EPC STORMWATER REVIEW COMMENTS  
IN ORANGE BOXES WITH BLACK TEXT

# SADDLEHORN RANCH - FILING 4

## CONSTRUCTION DOCUMENTS

SADDLEHORN RANCH - FILING 4  
COVER SHEET  
SHEET 1 OF 43  
JOB NO. 21542.06

SADDLEHORN RANCH - FILING 4
 TYPICAL SECTIONS
 SHEET 3 OF 11
 JOB NO. 25142.06

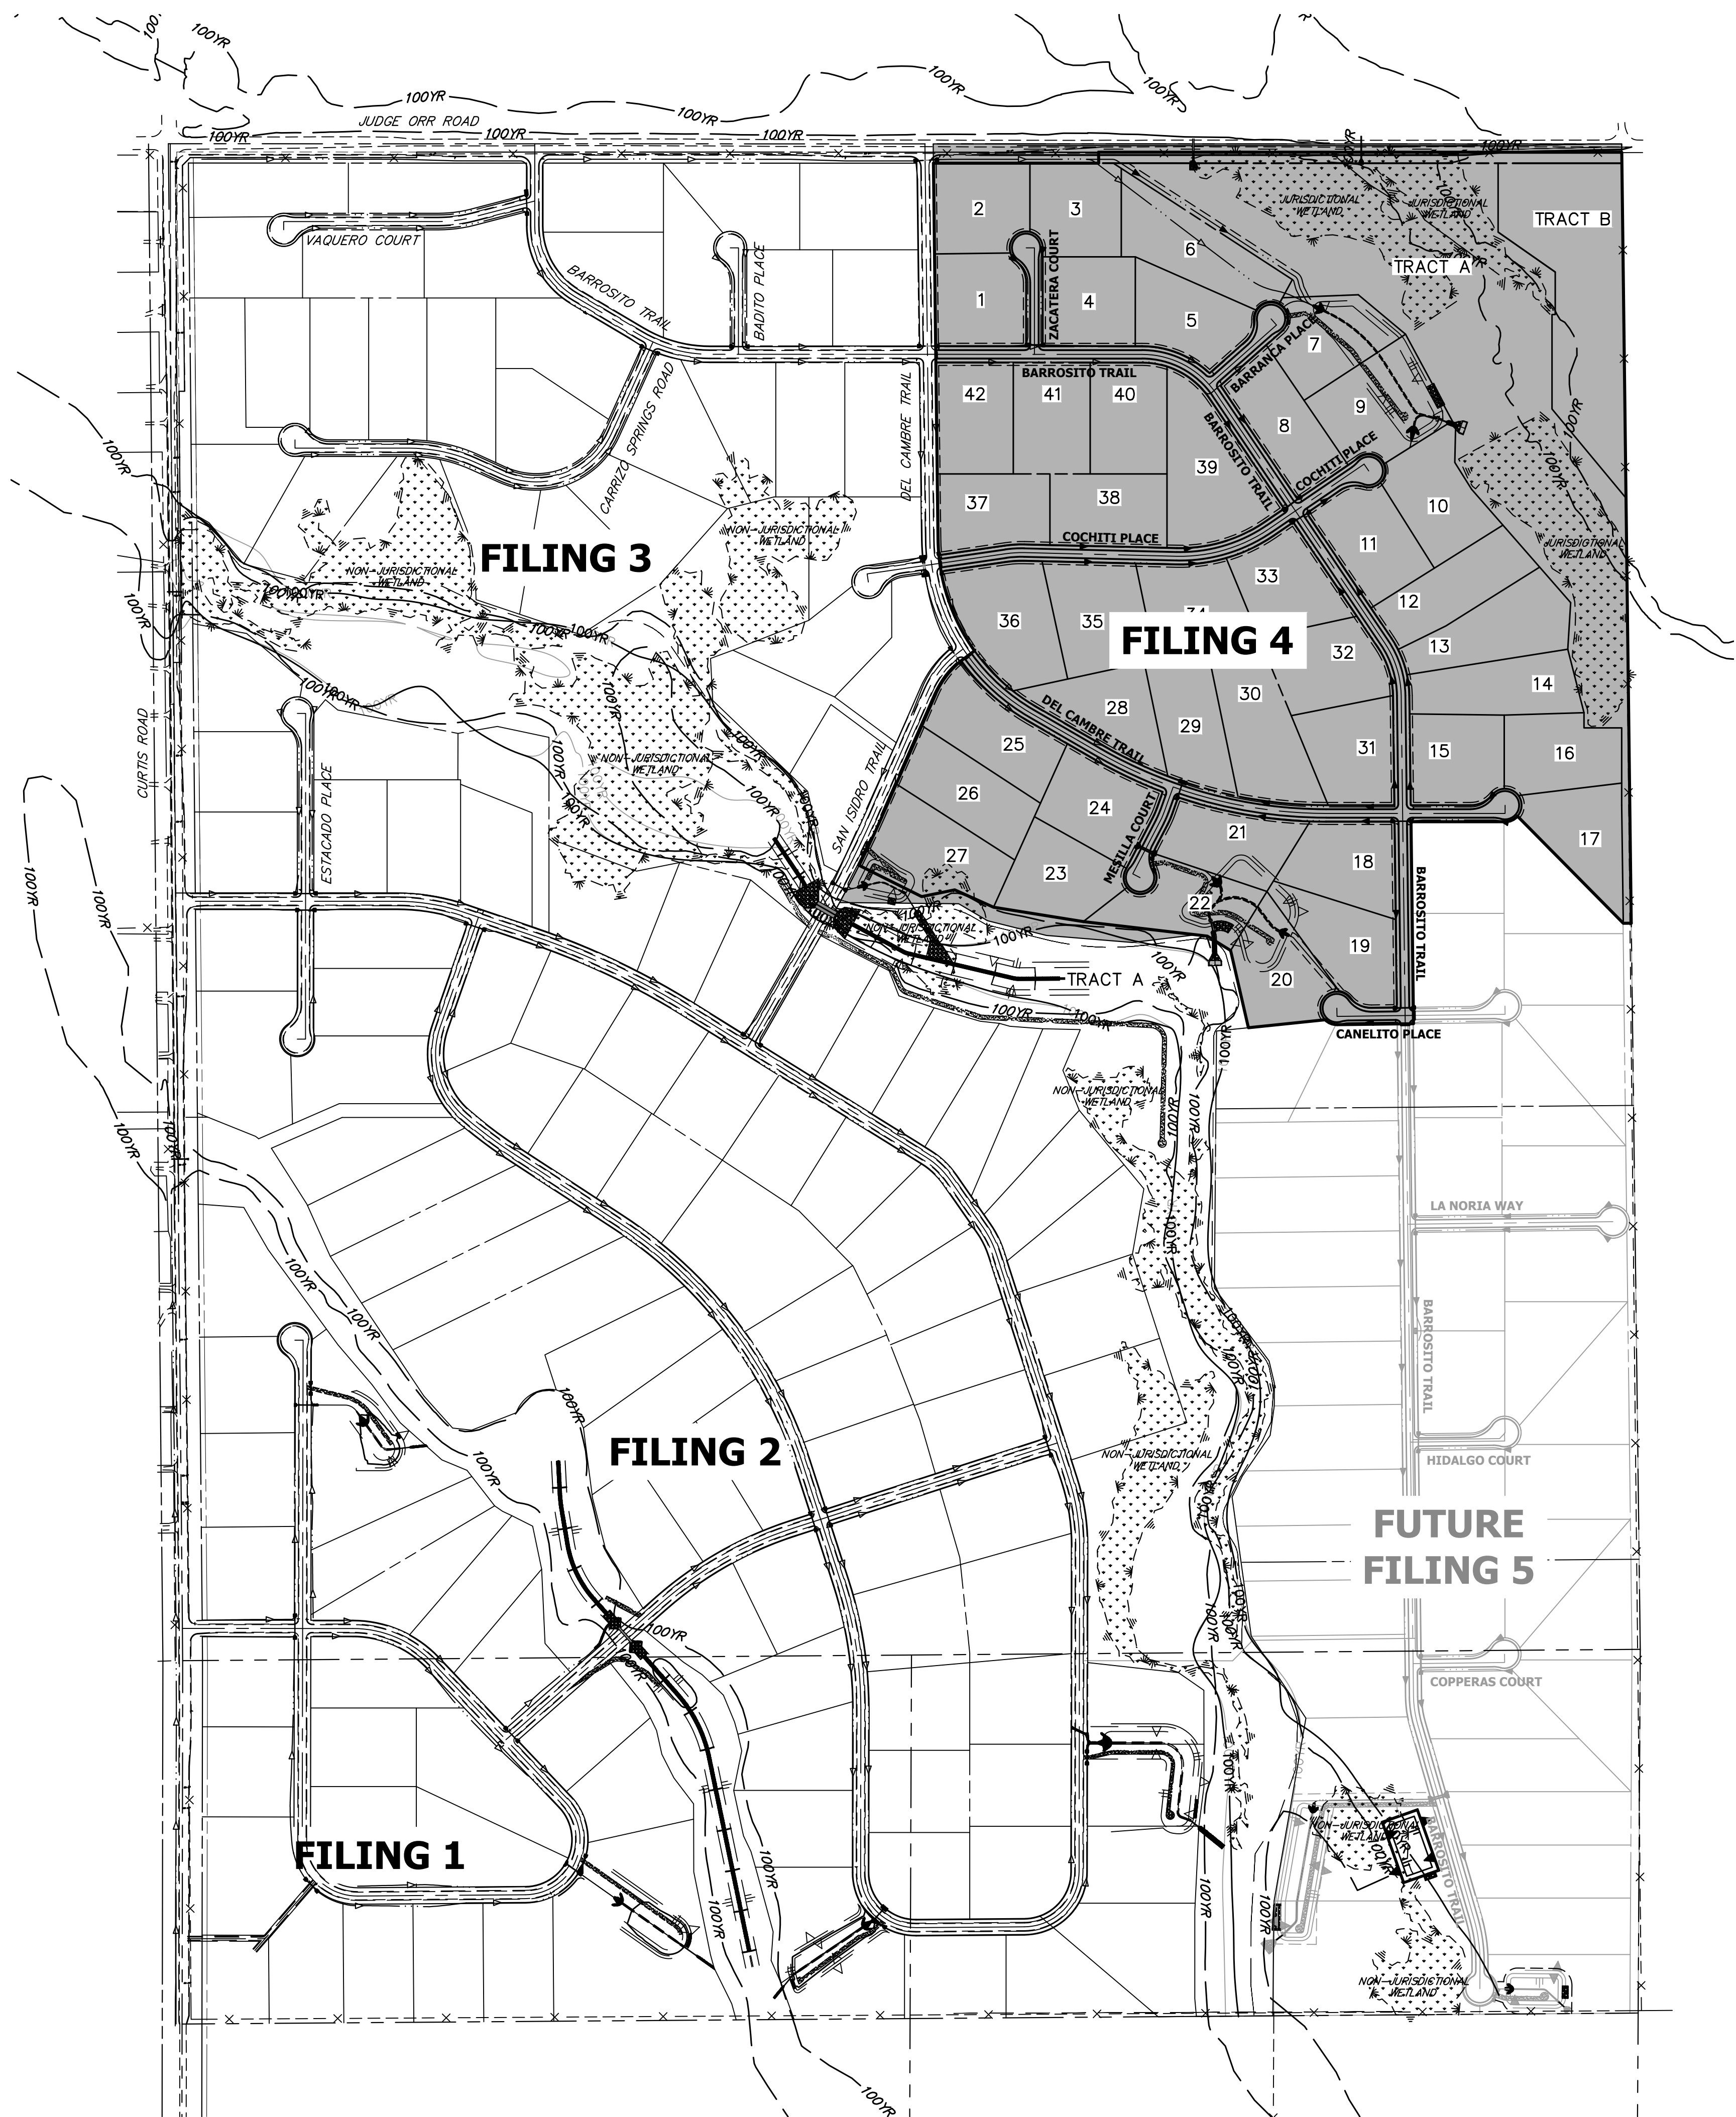
Section B-B on the GEC plans show these widths as 9' and 12' respectively. The depth is listed as 3' on the GEC Plans. Verify the dimensions and update so both the CDs and GEC Plans match.
